## 63 Clifton Street #2018-00121

I am currently reviewing your Fast Track application for 63 Clifton Street. Please provide revised floor plans with dimensions of both proposed bathrooms including dimensions of and between fixtures. You can send revised files directly to me. Thank you.

# 63 Clifton street , First Floor Bath Room Proposed Plan

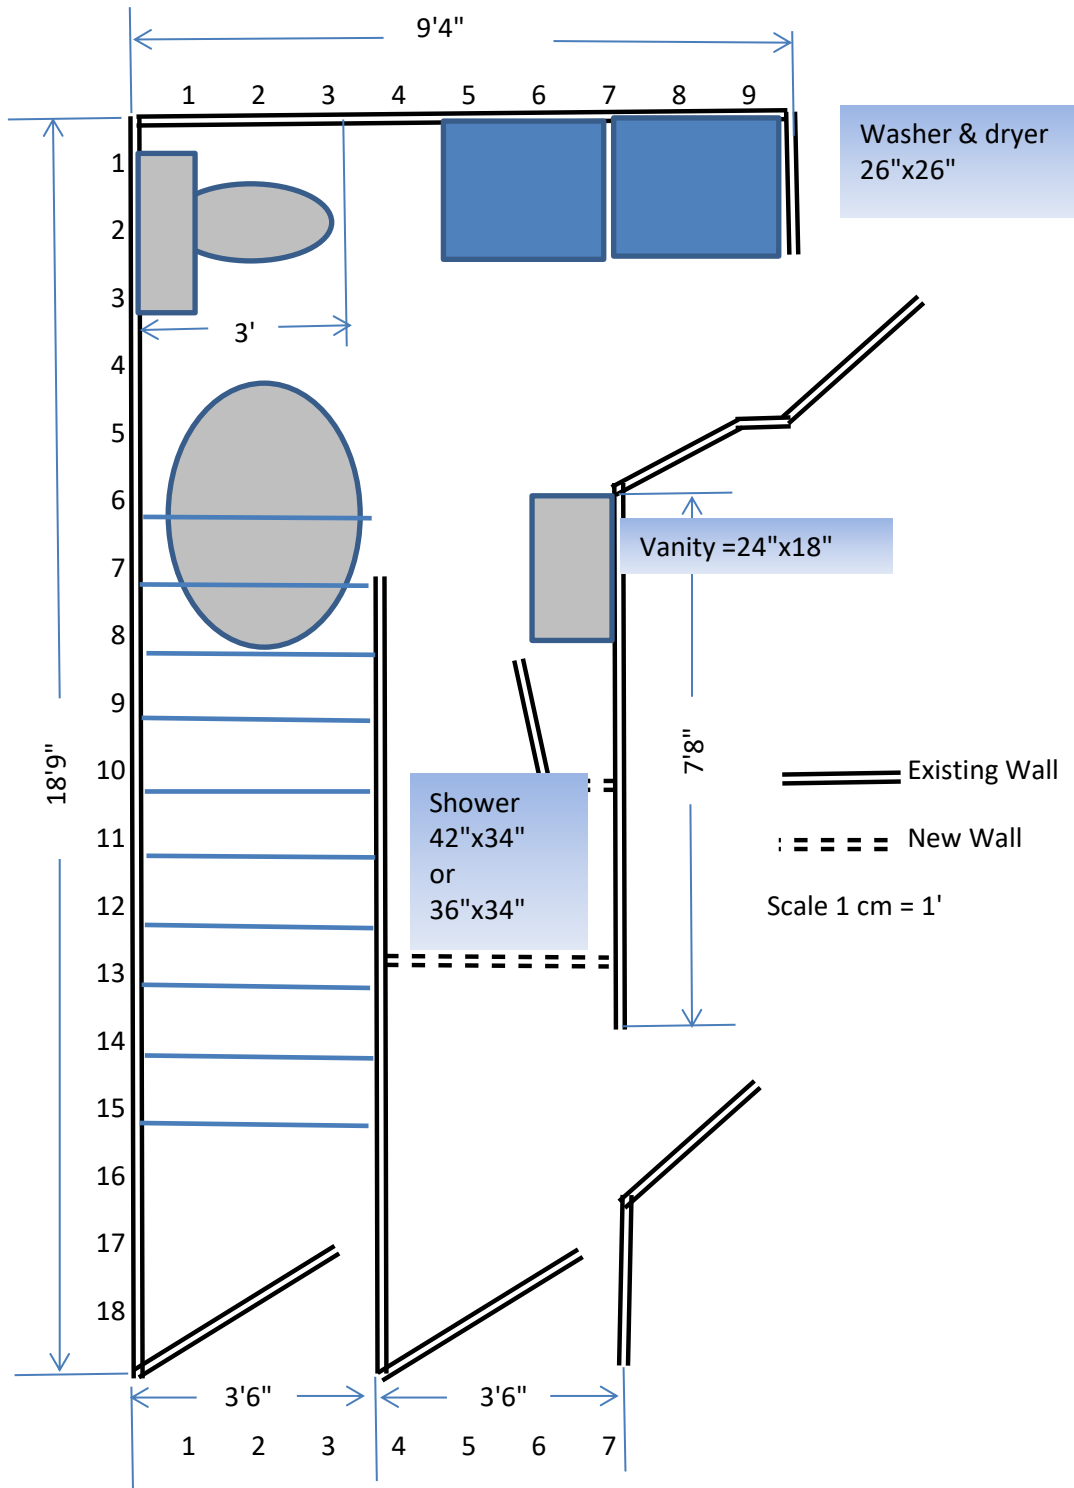
As drawn, your plans do not appear to meet the code requirements. Please note the following code requirements (refer to the 2009 International Residential Code and the 2015 Uniform Plumbing Code for all code requirements and exact language):

Bathrooms shall have a minimum ceiling height of 6 feet 8 inches at the center of the front clearance area for fixtures. A shower or tub equipped with a showerhead shall have a minimum ceiling height of 6 feet 8 inches above a minimum area 30 inches by 30 inches at the showerhead.

The clear space in front of any toilet or sink fixture shall be not less than twenty-four (24) inches (610 mm).

Thanks for your response and feedback on my bathroom plans. We have double checked the bathrooms with our contractor and the plumber. The bathrooms are meeting the code requirements as you pointed out in your email.
